**45 HEARNES LAKE ROAD, WOOLGOOLGA - MAJOR PROJECT APPLICATION
UNDER STATE ENVIRONMENTAL PLANNING POLICY (SEPP) (MAJOR PROJECTS)
2005**

I refer to our recent conversation regarding the PPR and the request that I address the individual matters raised in the Attachment 2 to submissions.

MAP 20
06265
Amendment No.
H

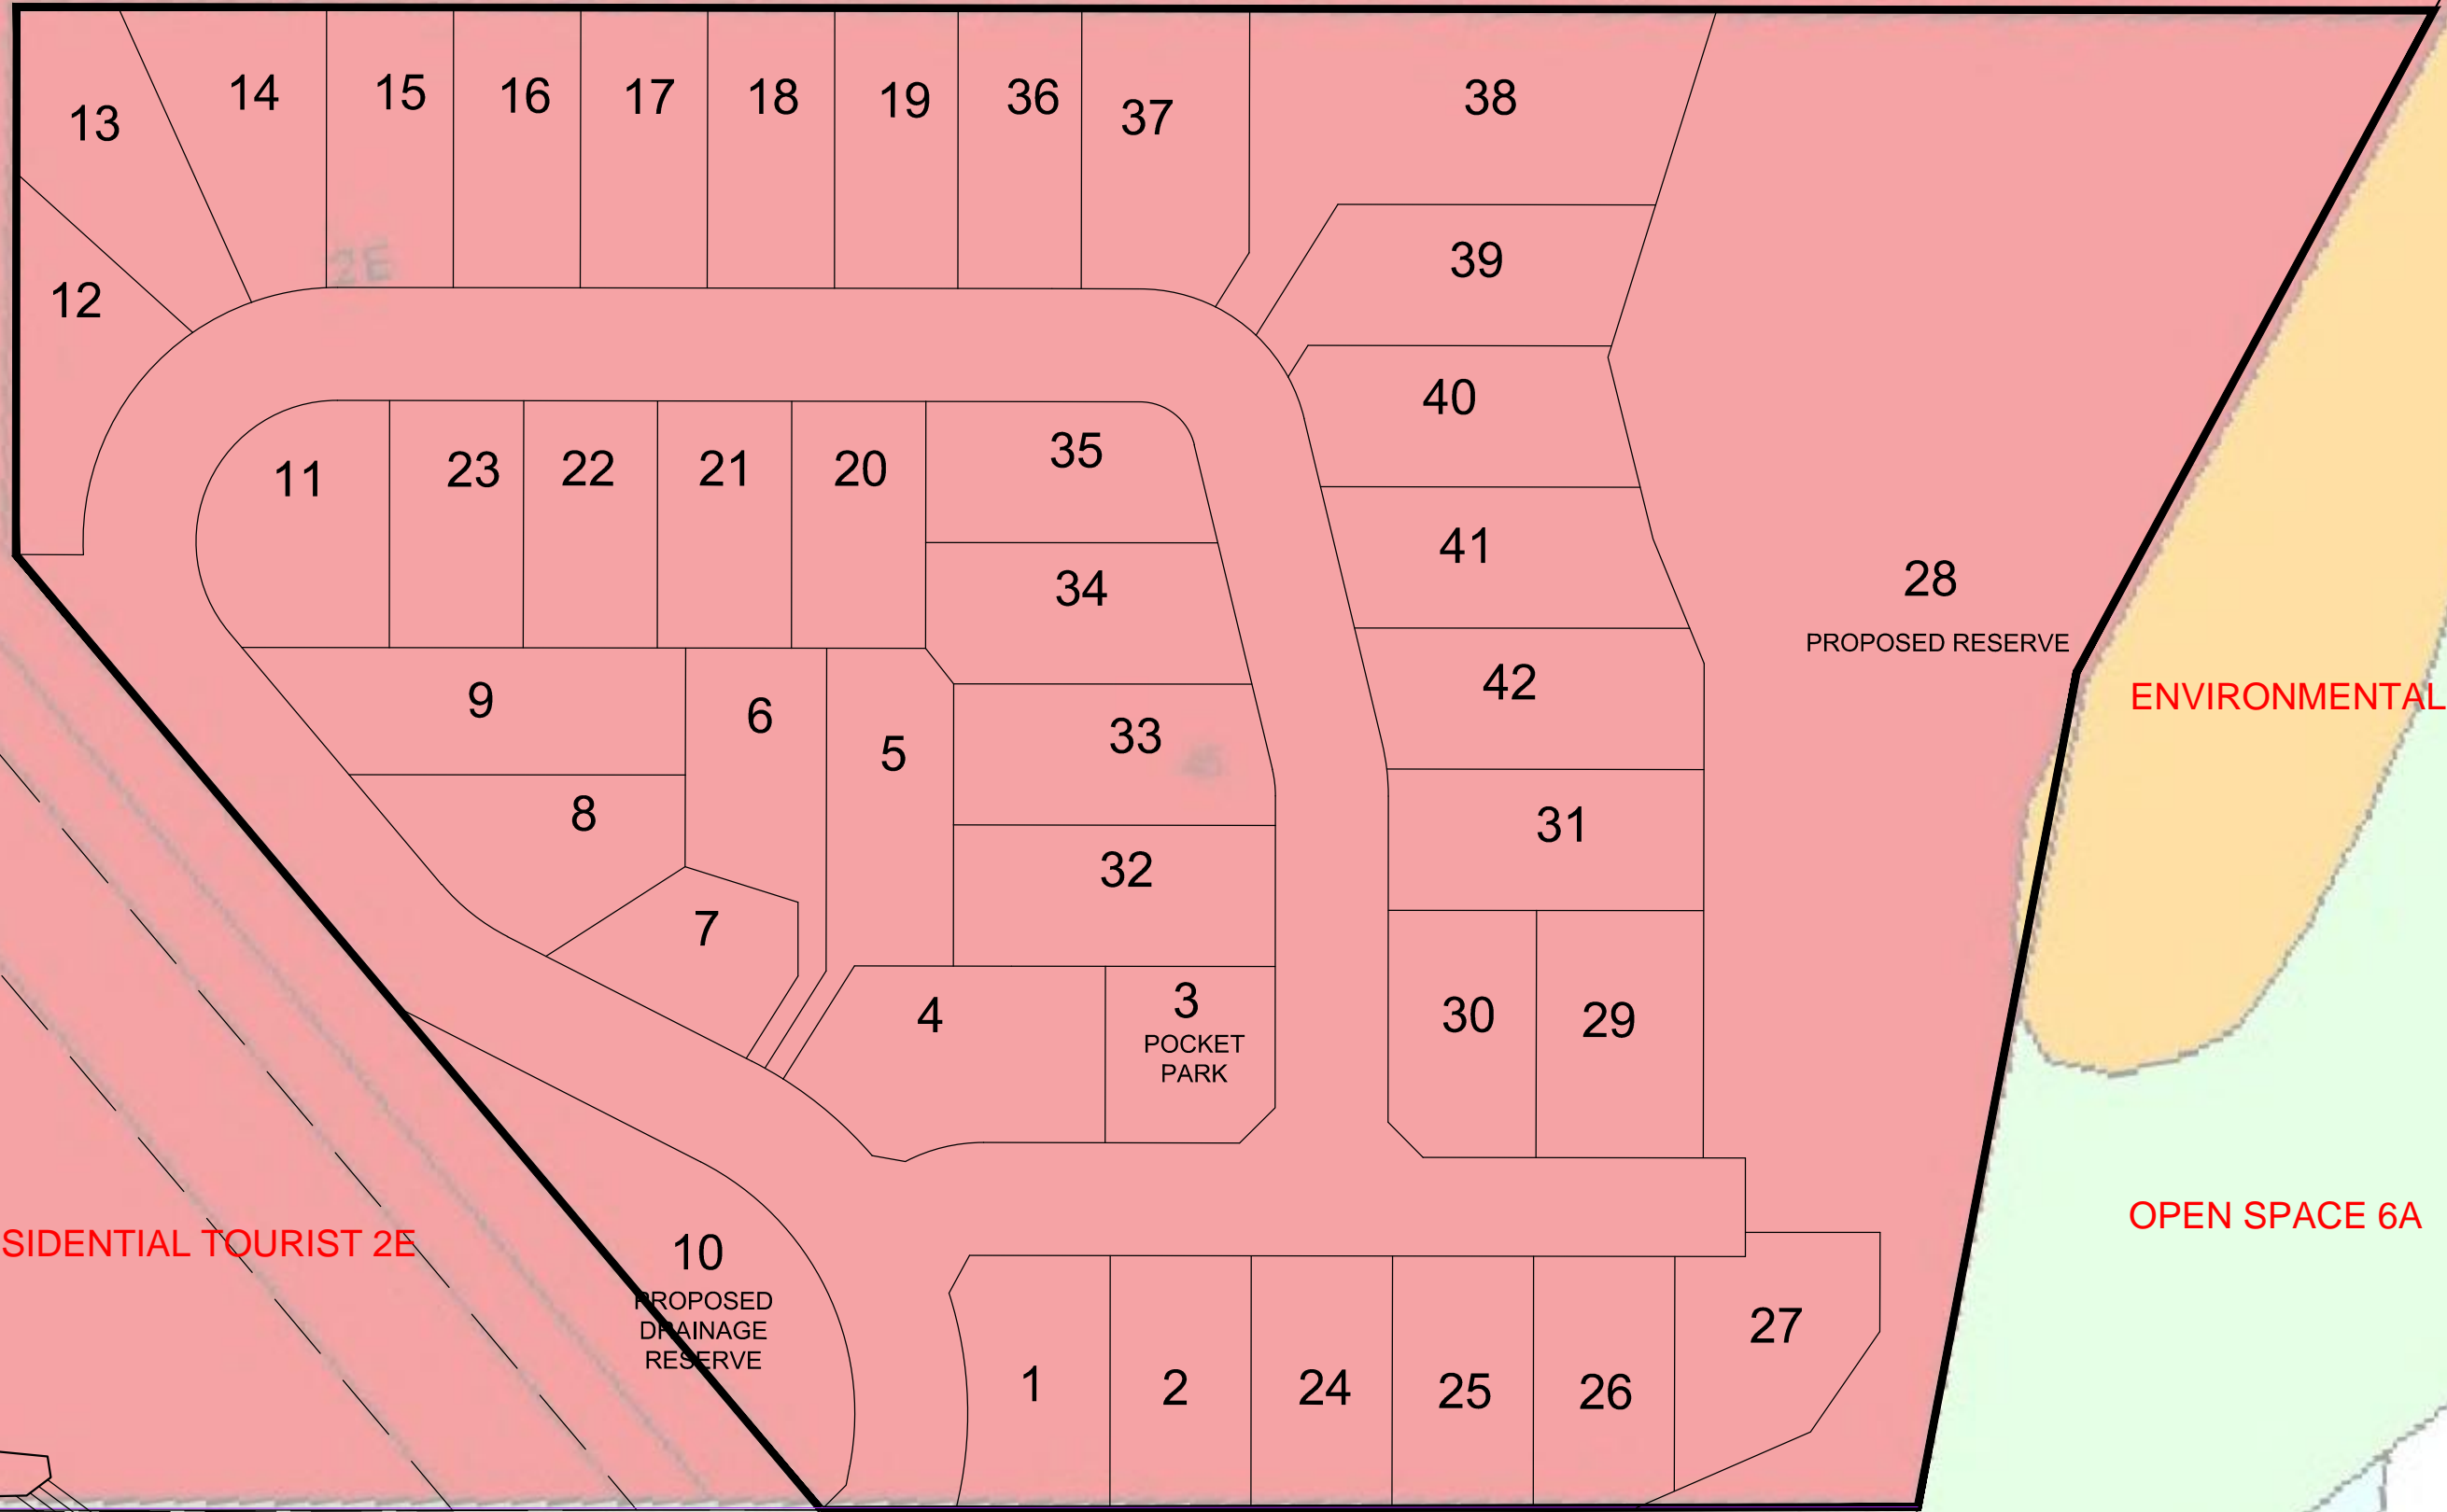
The site analysis plan should be amended to show the following site features:

- *the existing electricity easement that traverses across the western part of the site;*
- *steep land; and*
- *significance vegetation (SEPP26).*

- *Section 5.1.2 states that significant trees were identified before masterplanning and are proposed to be retained. Please provide a plan and schedule of trees that shows all trees on the site and identifies those to be removed and those to be retained.*

- *The constraints plan (Map 20) does not illustrate the location of the SEPP26 littoral rainforest and does not include all ecological buffers. Please provide an*

amended final plan that illustrates all constraints (SEPP26, EECs, threatened flora, contours) and associated buffers, eg: buffers to SEPP26, buffers to freshwater wetland EEC, Sainty Line as per Draft Ecological Plan dated 7 November 2008.

This information has now been included and shown on Maps 8, 20 and 23 included in the final plan set.

The proposed lots have now been amended to generally coincide with the zone boundary as it was intended to conform with the Agreed Conservation Line reflected on Map 20.

The significant trees are now included on Map 20 in the final plan set.

The constraints plan has been updated to include these requirements. The contours are shown separately on Map 23 for graphical clarity.
